TOWN AND COUNTRY PLANNING ACT 1990 FULL

Reference:	H16-0410-23	Date of Decision:	14th June 2023
Applicant:	Mrs F T Mir Javadi 13a Fishpond Lane Holbeach Spalding PE12 7DE		
Location:	106 Halmer Gate Spalding		
Description:	Change of use of residential dwelling to HMO - re-submission of H16-1111-22

J175-PL1C

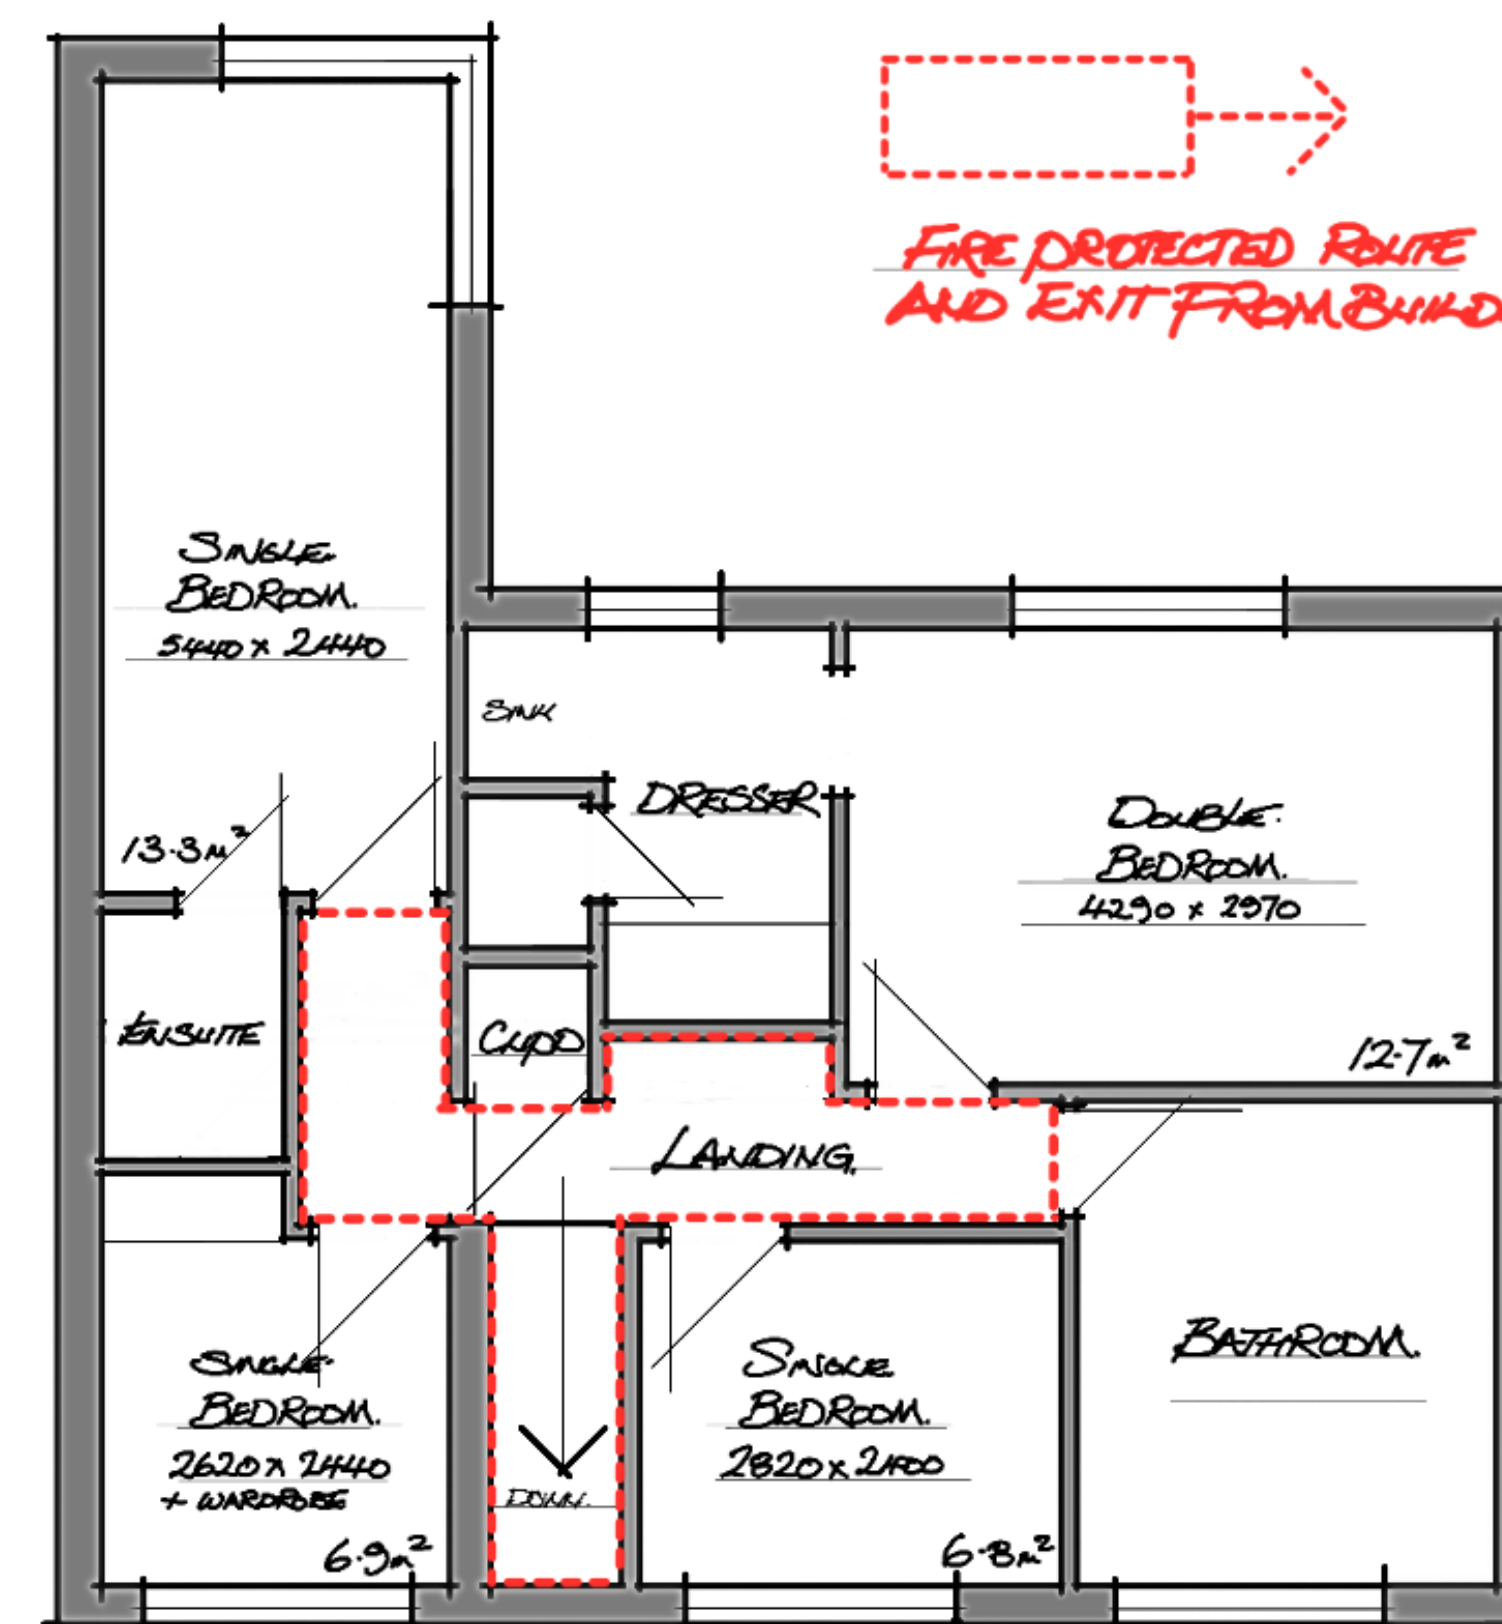
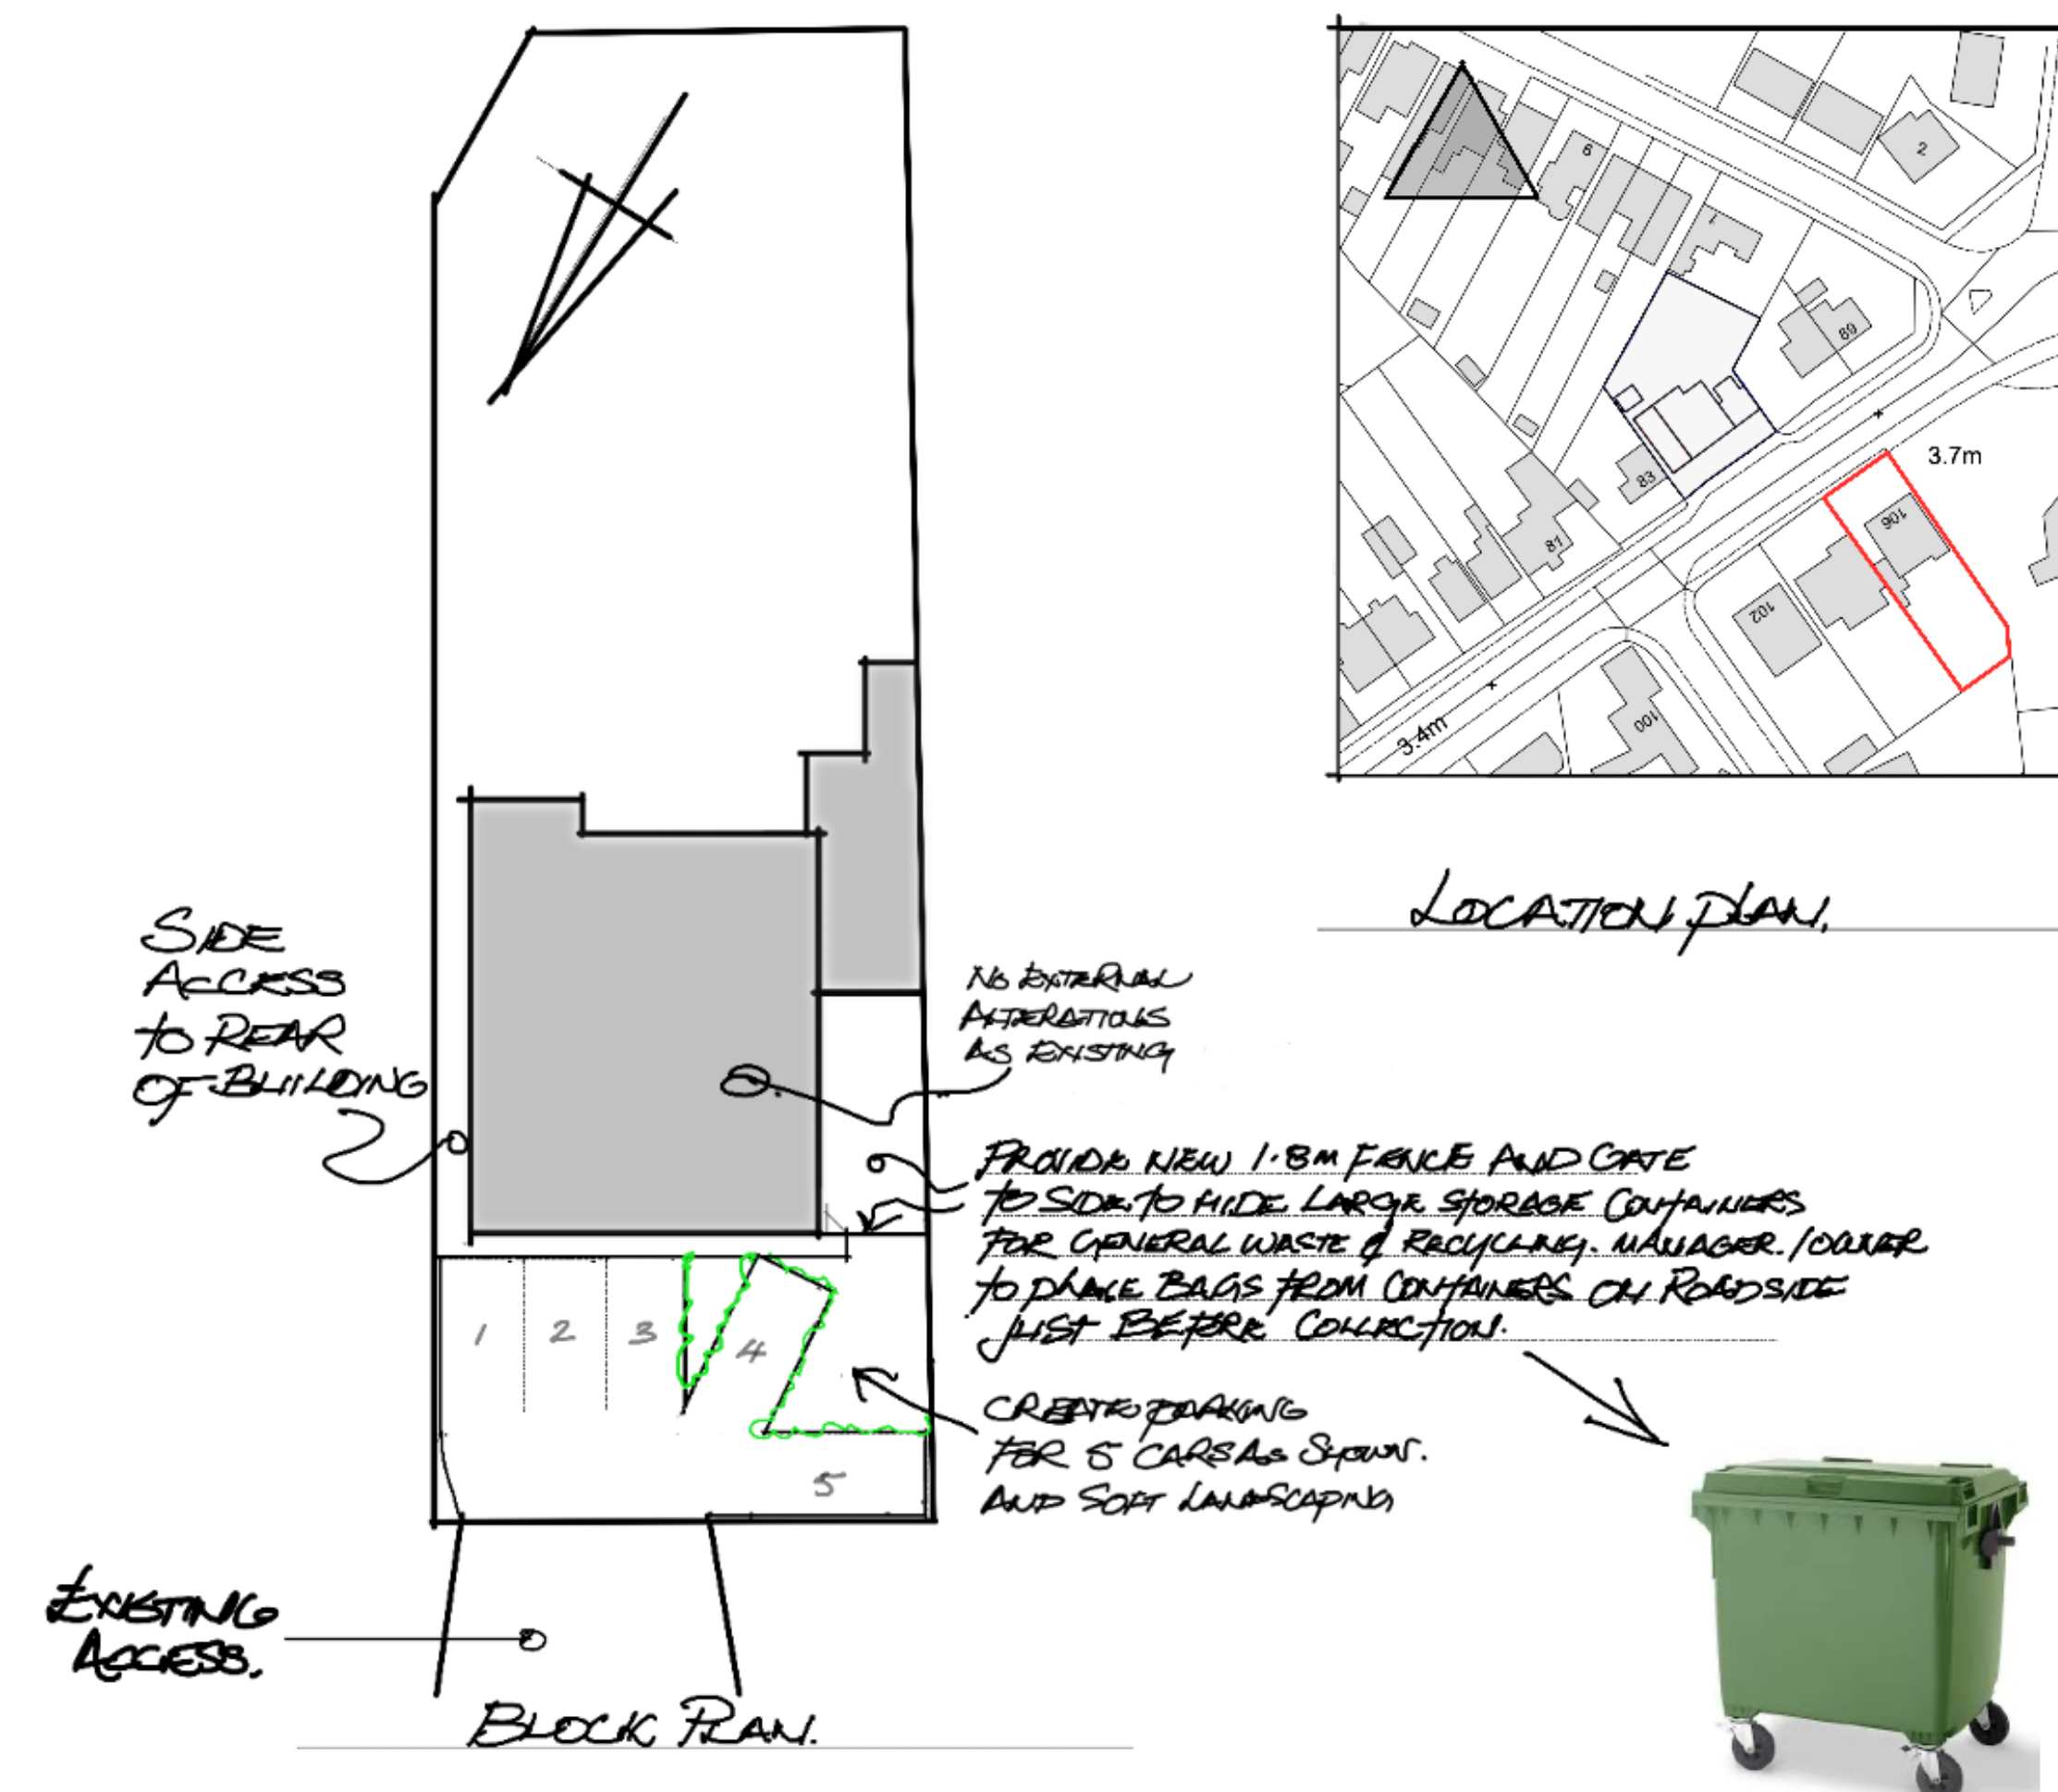
- 1 The property is considered to be of an inadequate size to accommodate what would likely be between seven and nine people by virtue of small bedroom sizes and inadequate amenity space. This insufficient amenity space would detrimentally impact the standard of living of potential occupiers. This directly contradicts criteria 7 of Policy 21 of the South East Lincolnshire Local Plan which requires sufficient amenity space for HMOs.

- 2 A single shared communal living room would be insufficient to meet the needs of at least seven residents, forcing residents to spend excessive time either within their own rooms or within the communal garden space. This increase in outdoor gathering would increase the levels of noise pollution to the detriment of neighbouring occupants. This explicitly contradicts criteria 2 of Policy 21 and Policy 2 and 3 of the South East Lincolnshire Local Plan which ensures that neighbouring amenity is not impeded by development.

- 3 Given that the HMO is intended to accommodate a minimum of seven persons, there is the potential for a large number of vehicles to be associated with the property. The application has stated that five parking spaces will be provided; however, two of these spaces would result in vehicles being obstructed and unable to manoeuvre. It is considered that this is insufficient parking space given the potential number of residents, and that as a result the proposal may lead to the indiscriminate parking of vehicles on Halmer Gate and would impede traffic flow along a road that is particularly busy. The lack of room for turning may result in vehicles exiting the property in reverse, potentially damaging the safety of road users.
